APPEAL MR P FIRTH

LAND ADJACENT TO 45 LOCKE AVENUE, BARNSLEY, S70 1QH

**APPEAL STATEMENT SUBMITTED
ON BEHALF OF THE LOCAL PLANNING AUTHORITY**

**LPA REF: 2019/0800
INSPECTORATE REF: APP/R4408/W/19/3240980**

LOWER GROUND FLOOR

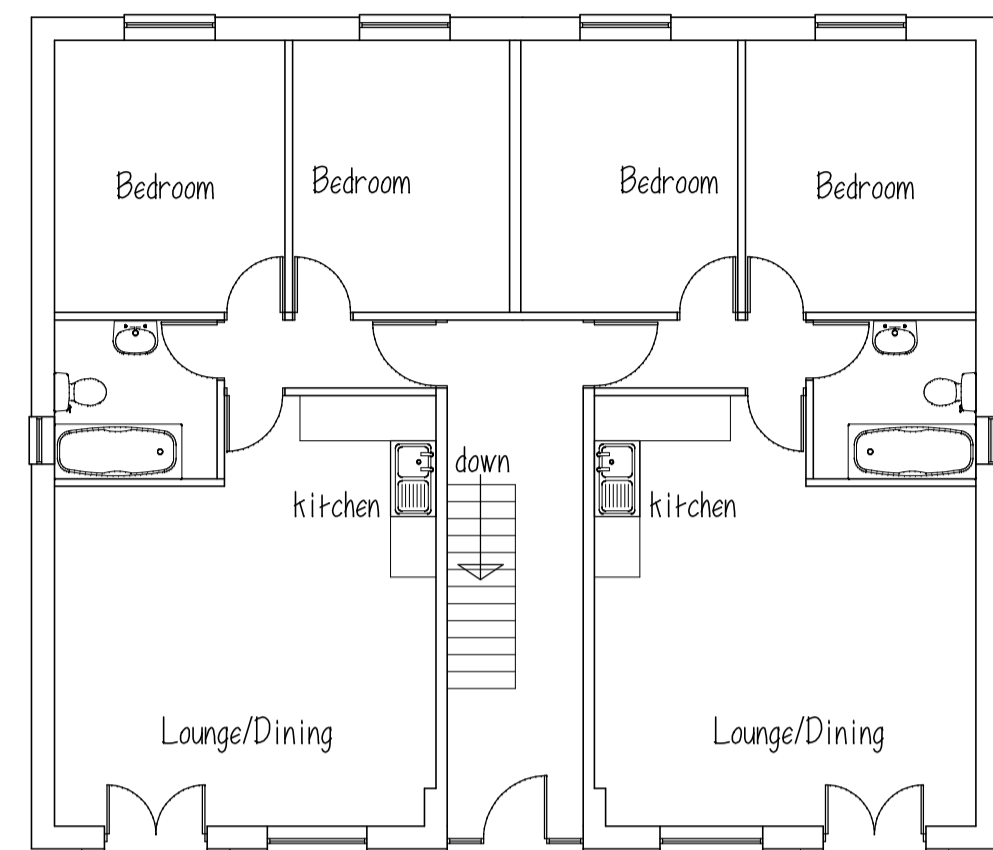
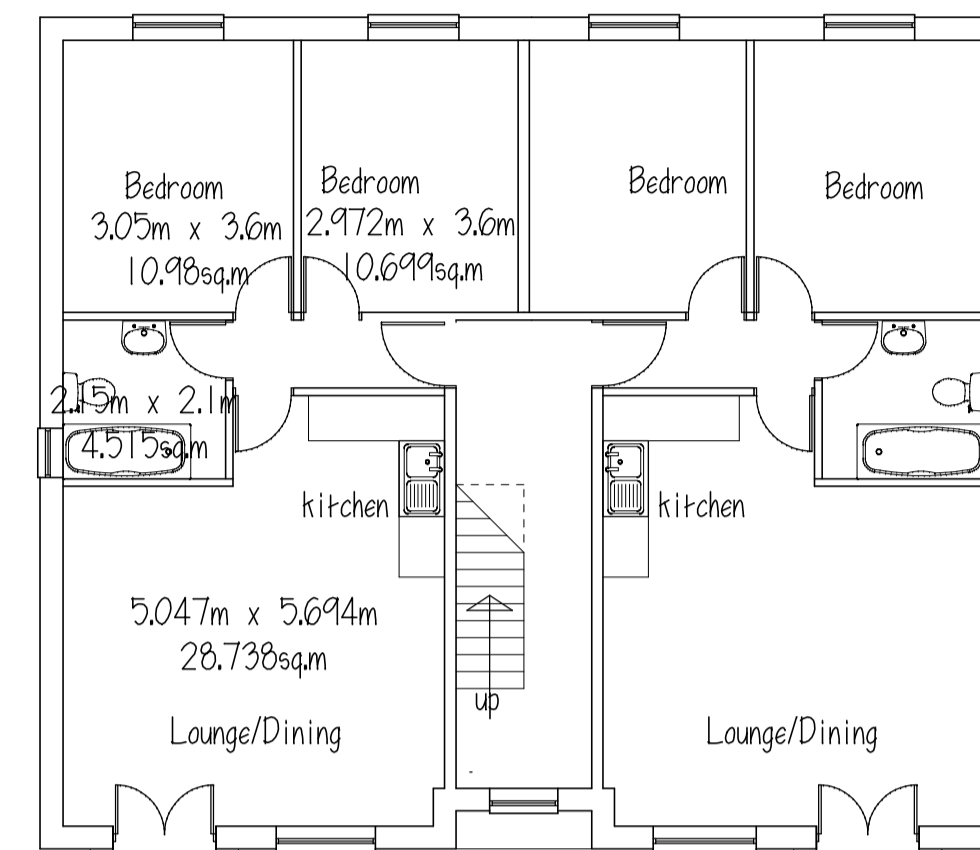
The building has been designed to take into account of the level differences between the site and Locke Avenue which have resulted in two basement flats, where the amenity of the future occupants will be severely compromised. These bedrooms would have a single window in the east elevation and would be located approximately 3.9m from the eastern boundary of the site marked by a substantial retaining stone wall approximately 3.1m in height, resulting in a very limited outlook for future occupiers. Furthermore, given the proximity and height of the boundary, this would result in an oppressive and unacceptable sense of enclosure.

SECOND FLOOR

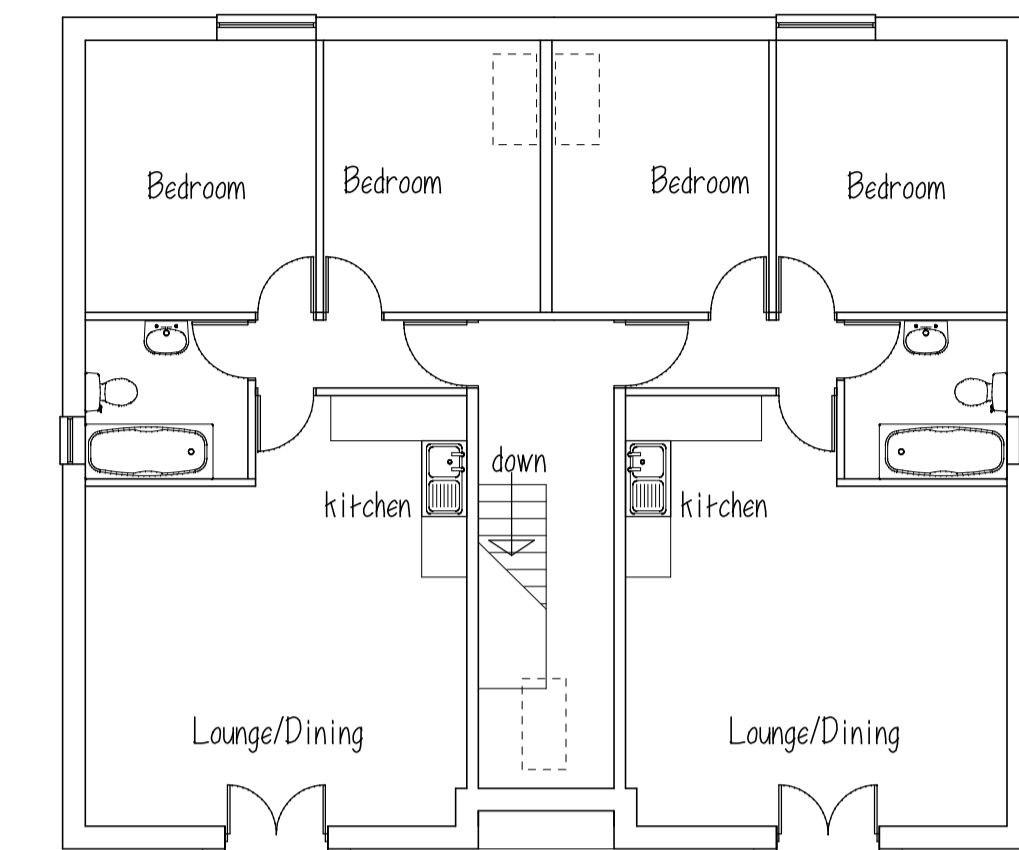
The appellant states that the shortfall in terms of floor space is minimal, it is acknowledged that flats fall minimally short of the overall floor area for a dwelling of this type; between 4m² and 7m² and in some circumstances these floor areas may have been considered acceptable, however, in this instance, flats 7 and 8 are to be located within the roof space of

the proposed buildings and due to the design and pitch of the roof would significantly reduce the useable floor space of these units to a substandard level.

FRONT ELEVATION

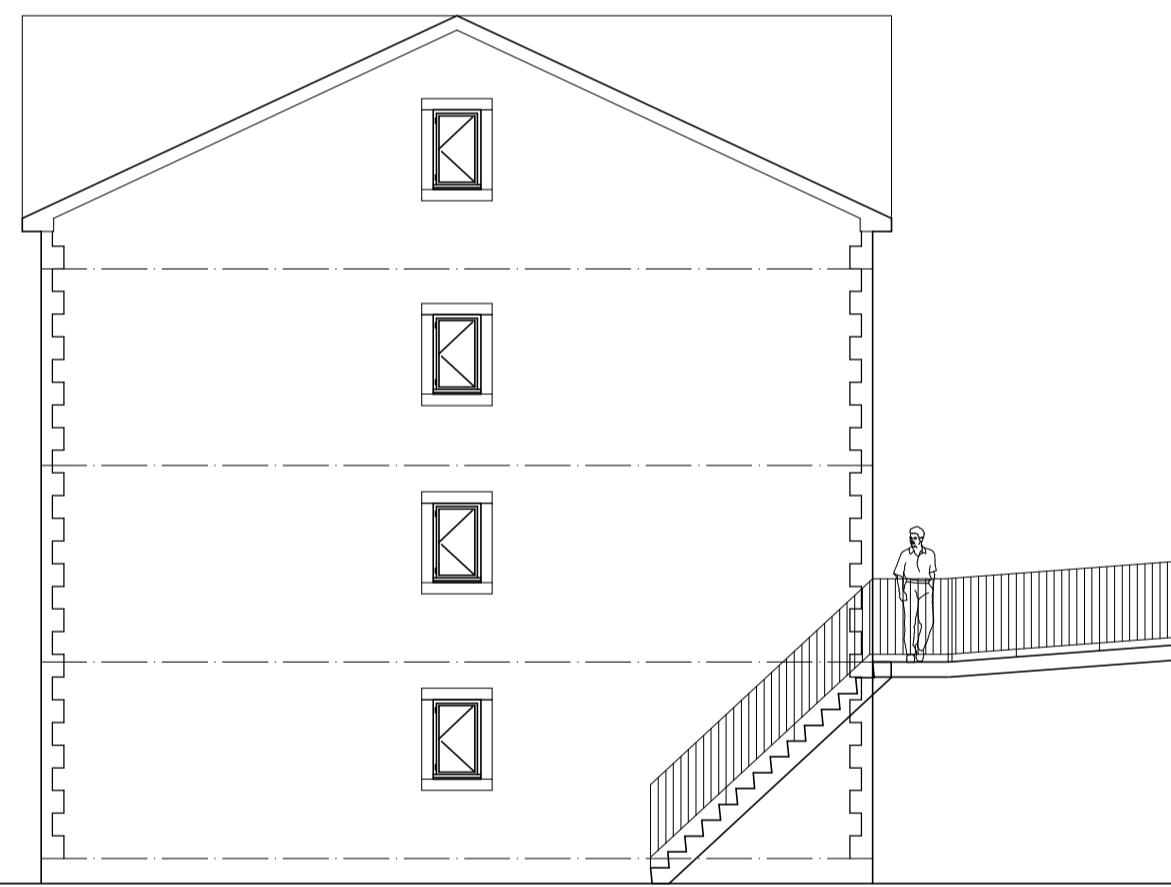
The authority does not dispute the area is characterised by a mix of house types and it is worth noting that a similar scheme (2018/1281), whilst was refused, was not refused on visual amenity grounds. However, that scheme was of a smaller scale and provided a better-quality balance between 263 Park Road and 45 Locke Avenue than the scheme proposed. In addition to this the design of the fenestration was more subdued and did not include a

proliferation of Juliette balconies on the front elevation, which are not characteristic of the area. Notwithstanding the above, this scheme was still considered unacceptable on 4 other grounds and was not subject to a planning appeal.

The proposed building would be large in both height and depth and would be developed close to the boundary with 45 Locke Avenue, approximately 750mm. The proximity of the building to the habitable room windows would have an unavoidable and overbearing presence that would dominate the outlook, harming living conditions of the applicant.
